TEXT_LittleCrow_ISH2_Session2_29062021

Okay, so turning to agenda item three A, which is a series of questions revolving around solar energy generation technology.

the applicants technical Guide, which is ret 1011, which is the document that was submitted

Balances and main results

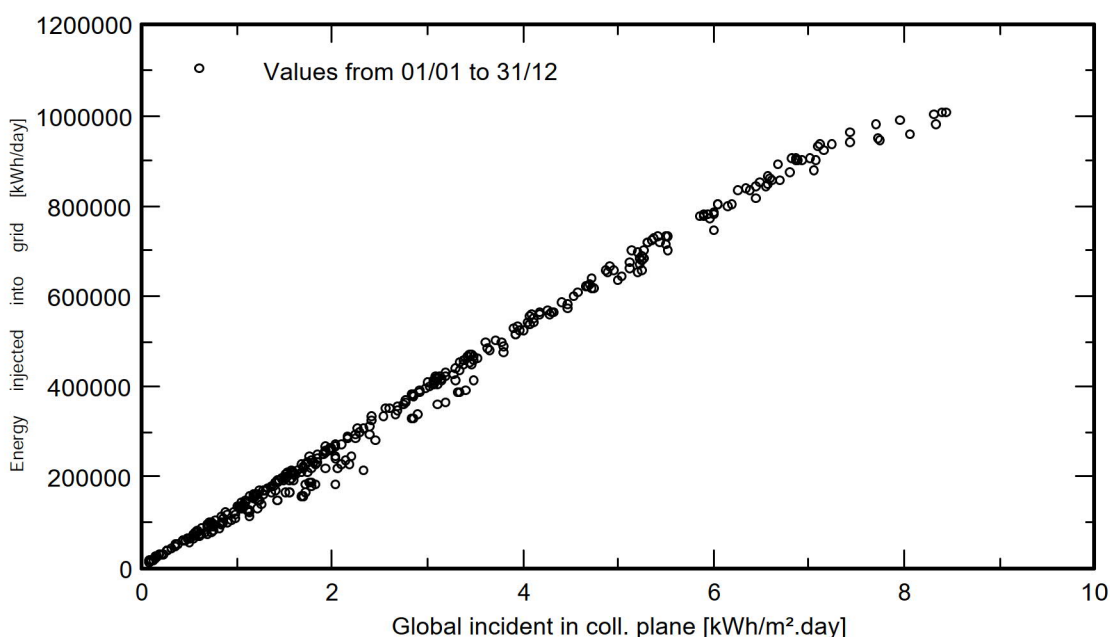
Now, my only slight query is the supplemental question to that is that when you look at the table,

and you look at the peoc, the performance ratio column and the total, the A, the 08, point four, five,

is that number, in effect, the average of the figures given for each of the months above? Yes, yeah. Then I think there might be a slight problem with that nought point 845 figure.

I've bashed it out on a calculator a couple of times. And I think the figure in the table should be naught point 815.

outside of the hearing, I'd ask that you go away, and you or the consultants have a look at that number and see whether it's right, because if that numbers, right, wrong, and should be the lower figure of naught point 815. I think those numbers add up to

It's not something I could answer, because actually, this is run by software. So you only put in certain parameters. And it produces the data based on the information you put in, which is location, number of megawatts number of inverters type of modules.

And the software has algorithms that actually produce the information you're looking at. So I wouldn't be able to comment, but I'll take that away. It may be more that it's something to do with the spread over

Grid-Connected System: Loss diagram

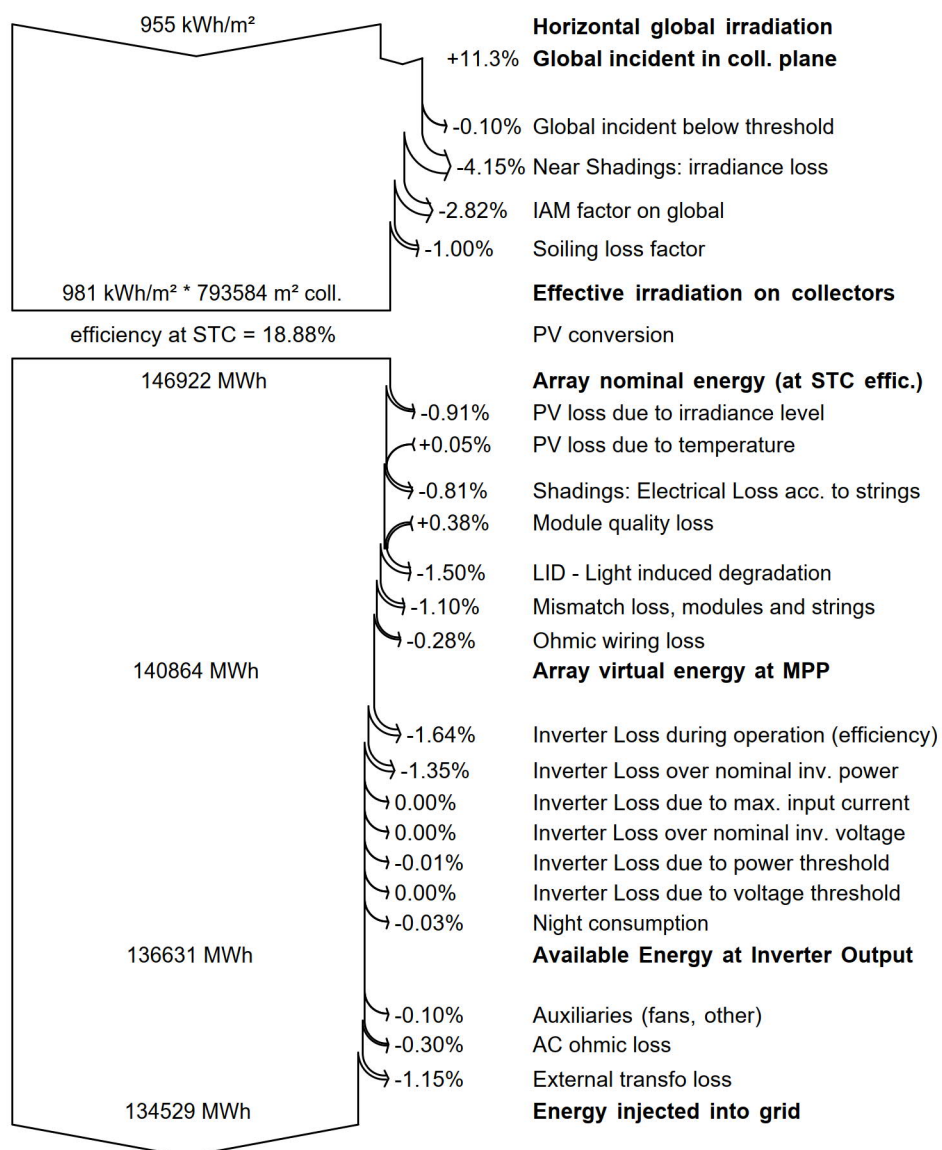
continuing to look at that table, or at the foot of page four in the simulation, but also looking at page six of the simulation, where the there's a lot of diagram shown.

for the lower part of of that chart or that figure or that diagram, the top bit where you get from 955 kilowatt

to the 981 kilowatt per

And actually addition, I kind of got lost, or is that something that you can talk me through? Or is it again, is that something that might usefully just be explained? In what you refer to as appendix four to the technical guide? Then you appendix four to the technical guide? Yeah, I think it'd be a lot easier to explain that in written form.

losses and their effect on the irradiation are

a bit complex, I suppose score quite difficult to I don't think it might be that there's percentages on percentages which affects what you what drops out at the bottom. Yeah, and and

loss factors are at different times of the year because some of the losses aren't effective in summertime, but they are, are effective in summer but not a winter, for example, with you know, temperatures of modules increasing and things like that. So it's not a sometimes it's not just a simple math.
